**M3 Junction 9 Improvement**

**Application by National Highways for an Order Granting Development Consent**

**Local Impact Report**

**Hampshire County Council**

DRAWING TITLE  
**TRAFFIC REGULATION MEASURES  
APFP REGULATION S(2)(c)  
SHEET 8 OF 10  
DOCUMENT REFERENCE: 2.11**

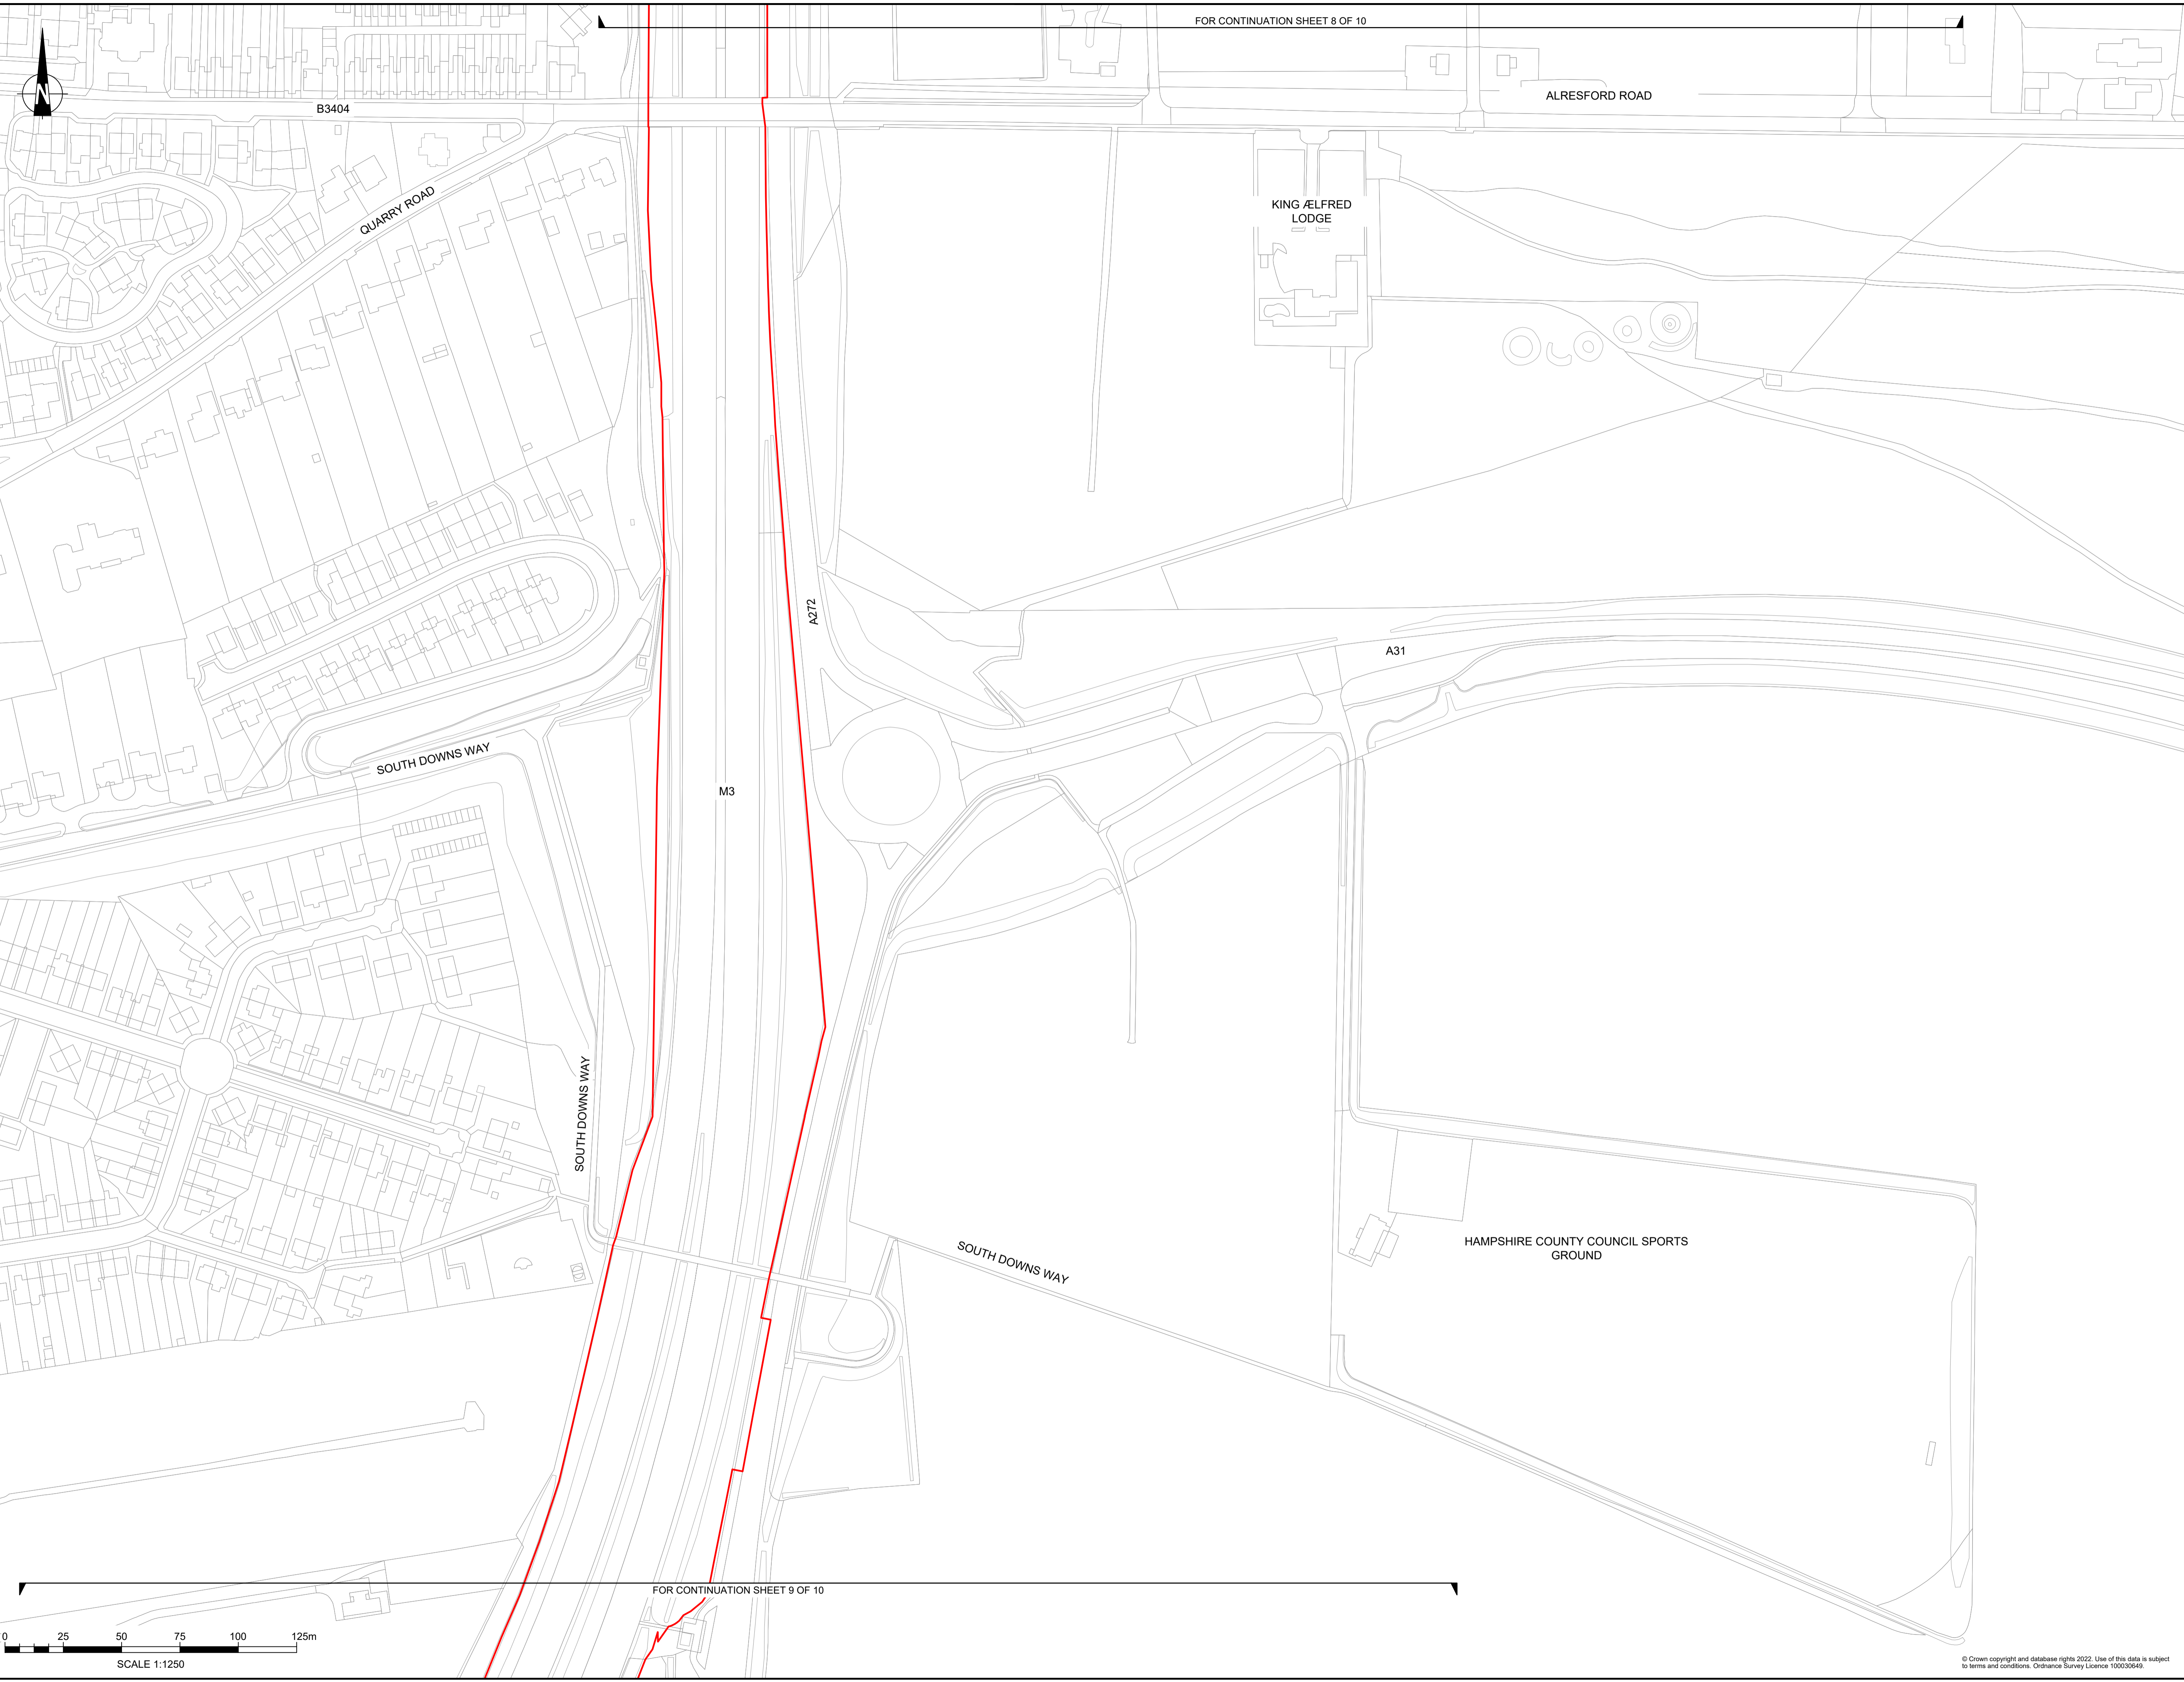
- 6.6.15 There are some outstanding queries and anomalies relating to where trunk roads and classified roads start and end. For example, on Classification of Road Plans Sheet 7 of 10 - where the local classified road appears to enter the gyratory which is part of the trunk road network. These details have been raised with National Highways and updated drawings are awaited.
